A303 Sparkford to Ilchester Dualling Scheme TR010036

Statement of Common Ground - South Somerset District Council's further comments of 24/05/2019 for Deadline 7.

Nicholas Wall
South West Heritage Trust on behalf of South Somerset District Council
24th May 2019

BUNDS AND FALSE CUTTINGS

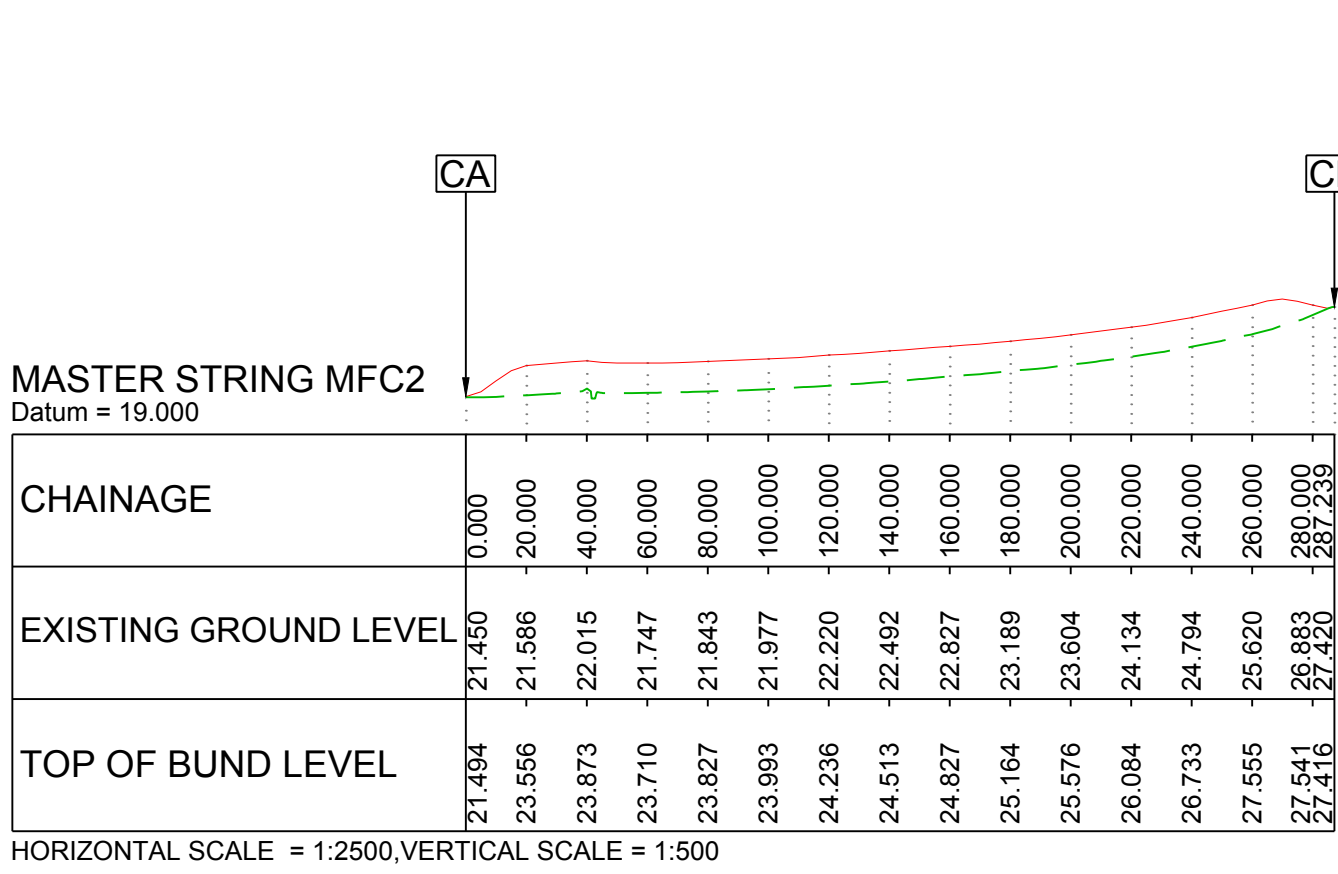
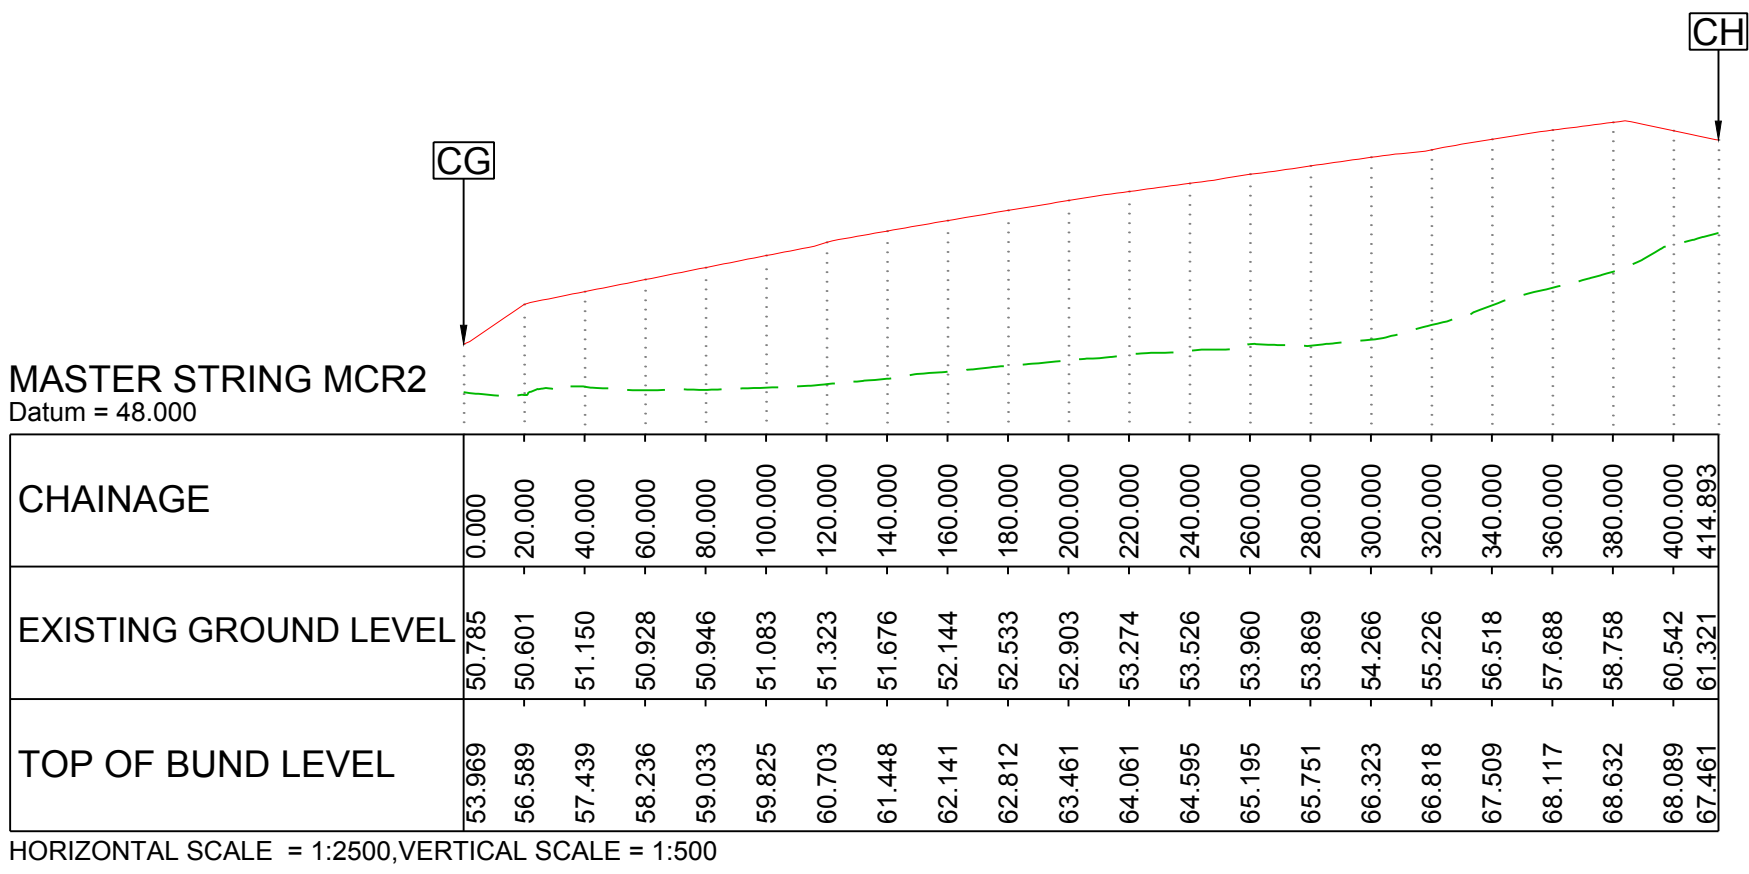
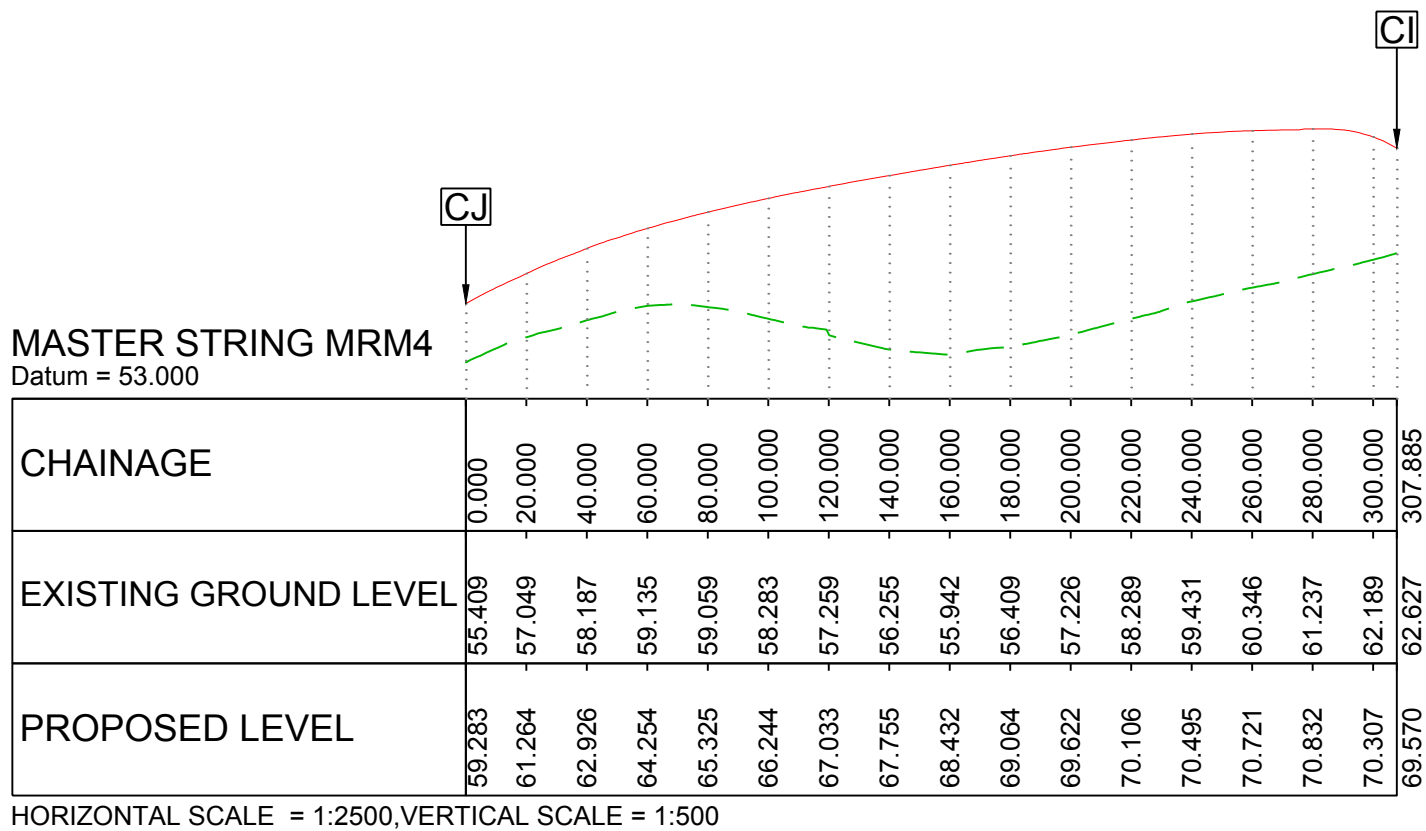
Landscape	Design and mitigation measures	Visual Receptor No. 38 – Implementation For the reasons stated above, the proposed mitigation measures are not considered effective. The Council considers that appropriate measures would be to relocate the drainage ditches and culverts to the east and to extend Bund 7 to the east, thus removing the need for the environmental barrier. The views of the Council were shared at the Bristol meetings on 22nd March 2019, with a helpful response from the Applicant to look at redesigning this area as part of the outline plan.	The Applicant is currently exploring this.	UNDER DISCUSSION	<p><u>Mitigation</u></p> <p>With regards to appropriate mitigation measures, please refer to the SSDC's response to ExQ2.5.6 in Deadline 5 and to the Council's response on Bund 7 above.</p> <p><i>(Retain status as UNDER DISCUSSION or change to NOT AGREED).</i></p>
